Application H04-0184-24
Location Land to the West of Cowbridge Road Bicker Fen Boston
Proposal Details of Landscape & Ecological Management Plan (Condition 19 and also relating to Conditions 17, 18 & 20 of H04-0849-22)

Name Black Sluice Internal Drainage Board
Address Station Road Swineshead Boston PE20 3PW

Date Submitted 11-03-24
For/Against Objections

Appendix 1: Landscape Masterplan

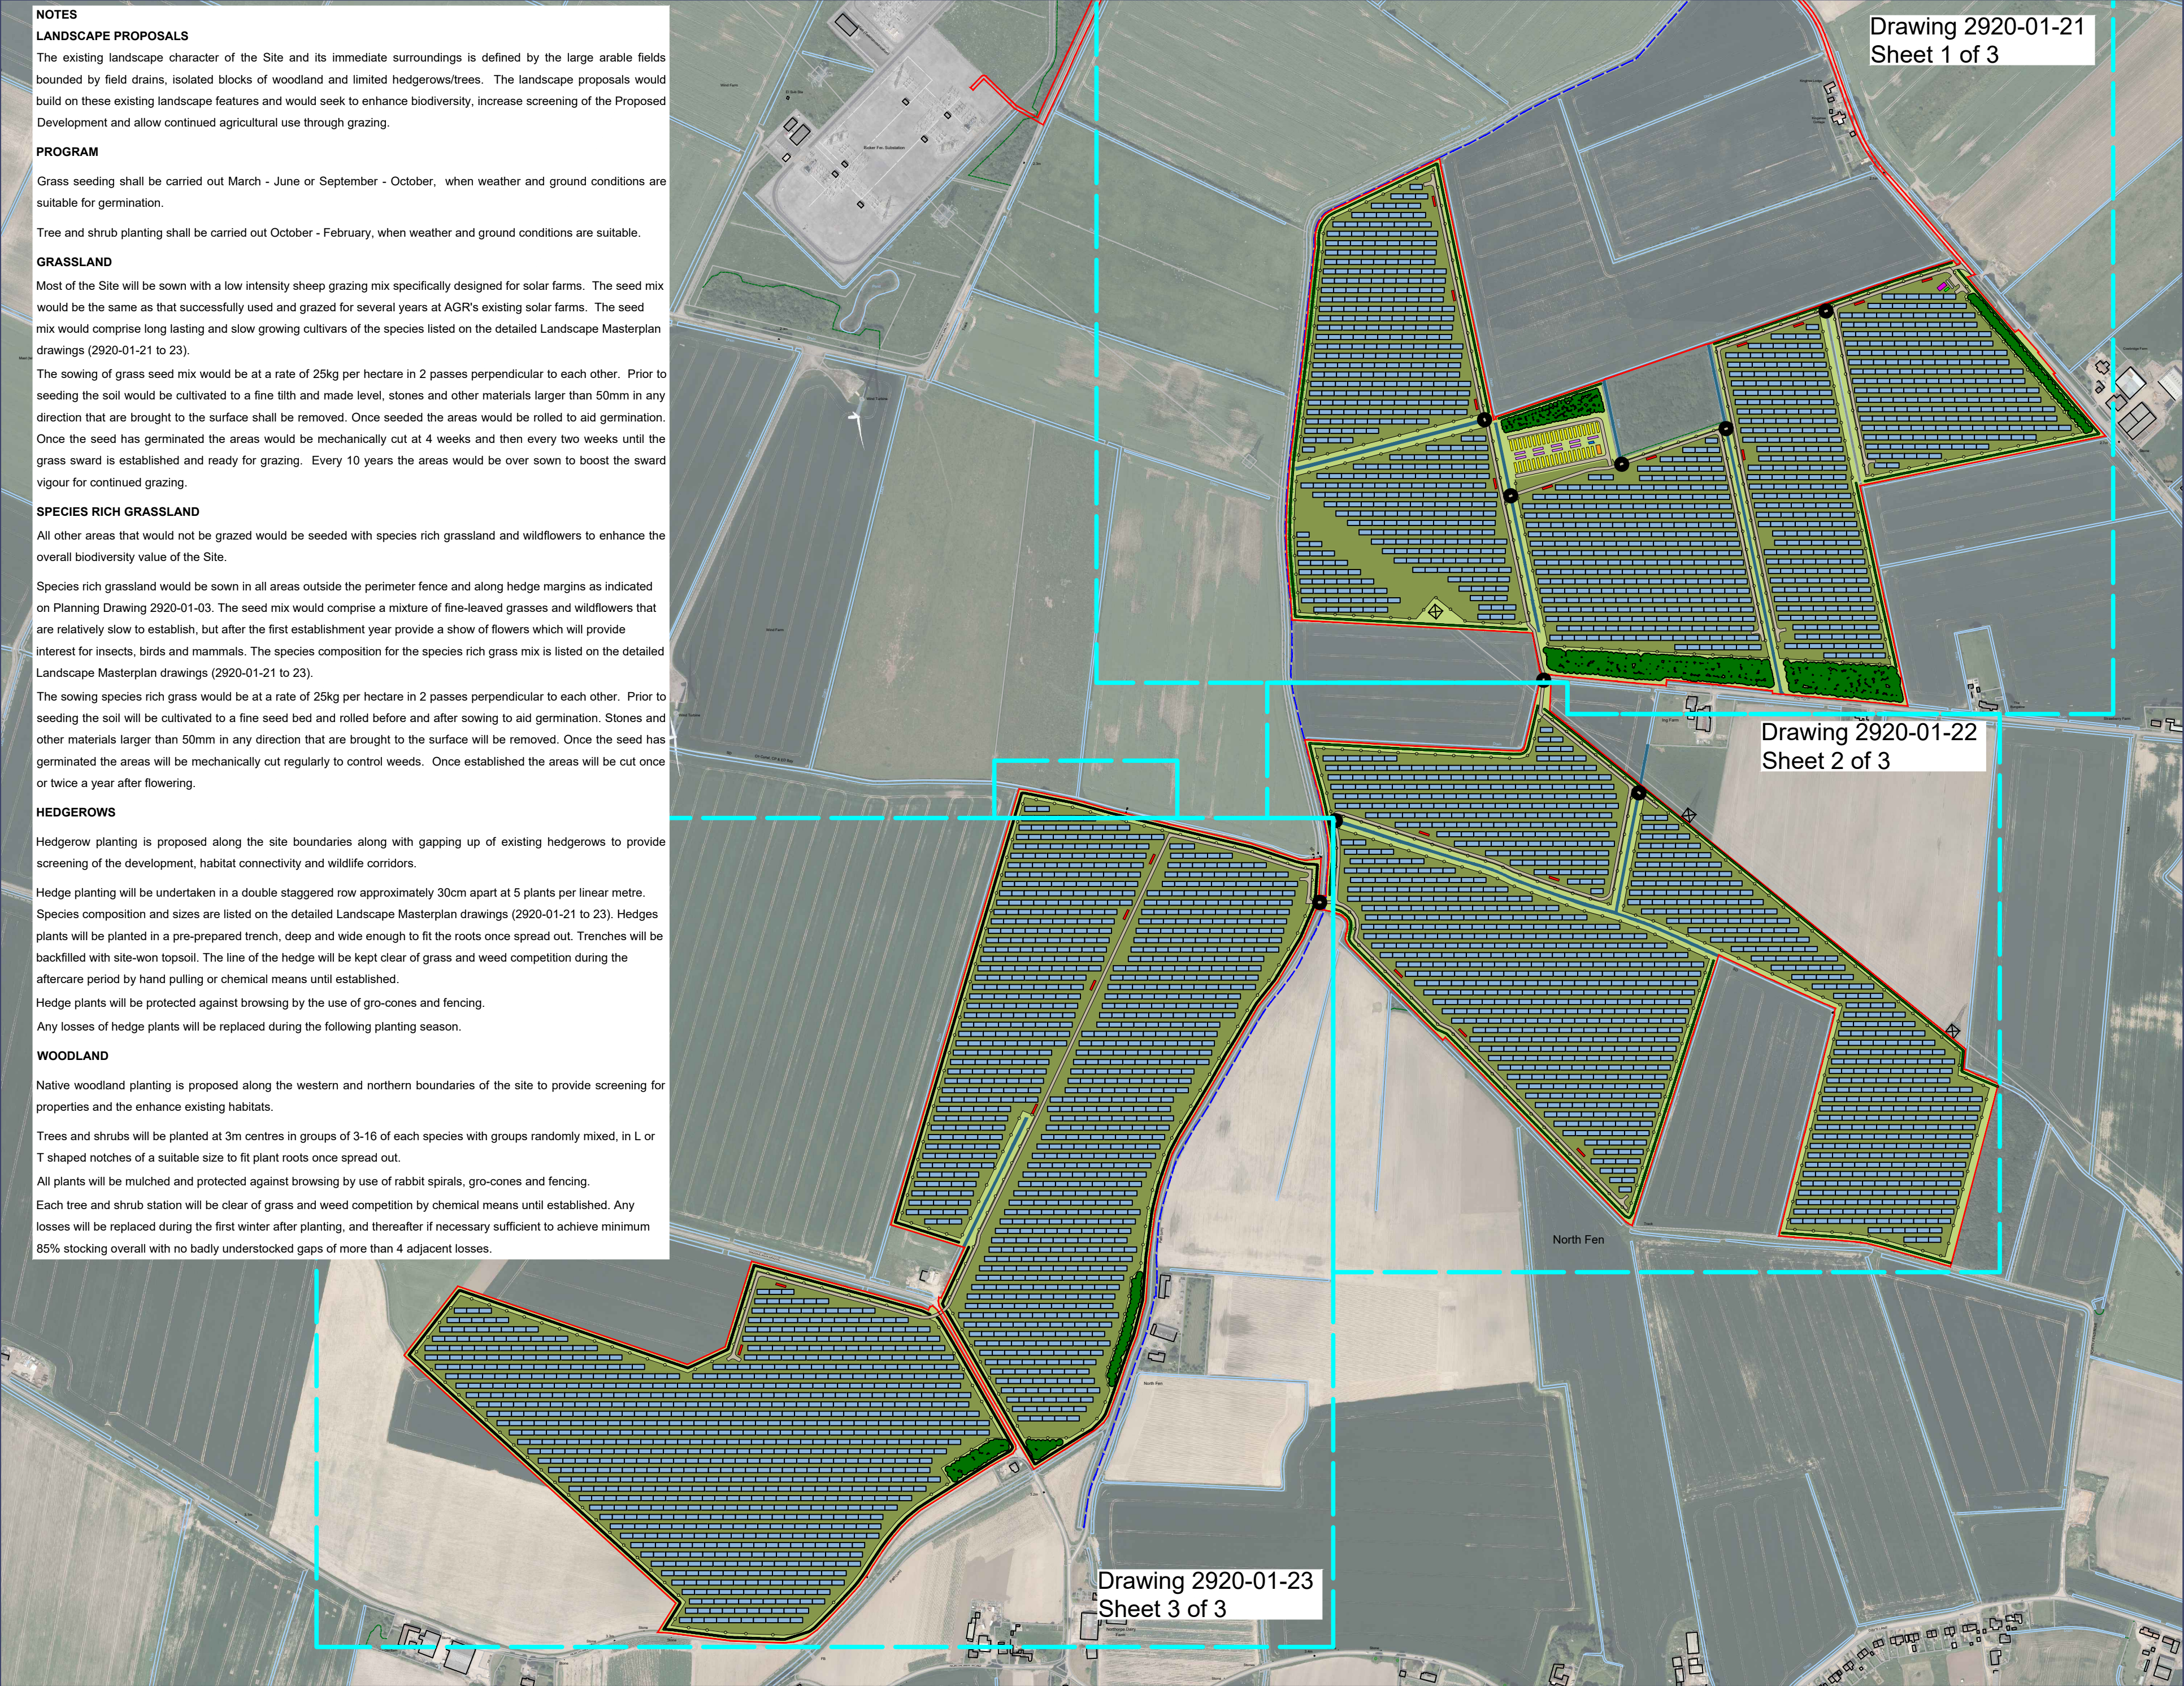
It would appear from the plans provided that the applicant intends to plant hedgerows within 9 metres of IDB-maintained watercourses. The applicant is advised that this will not be acceptable to the Board, and as such the Board OBJECTS to this application.
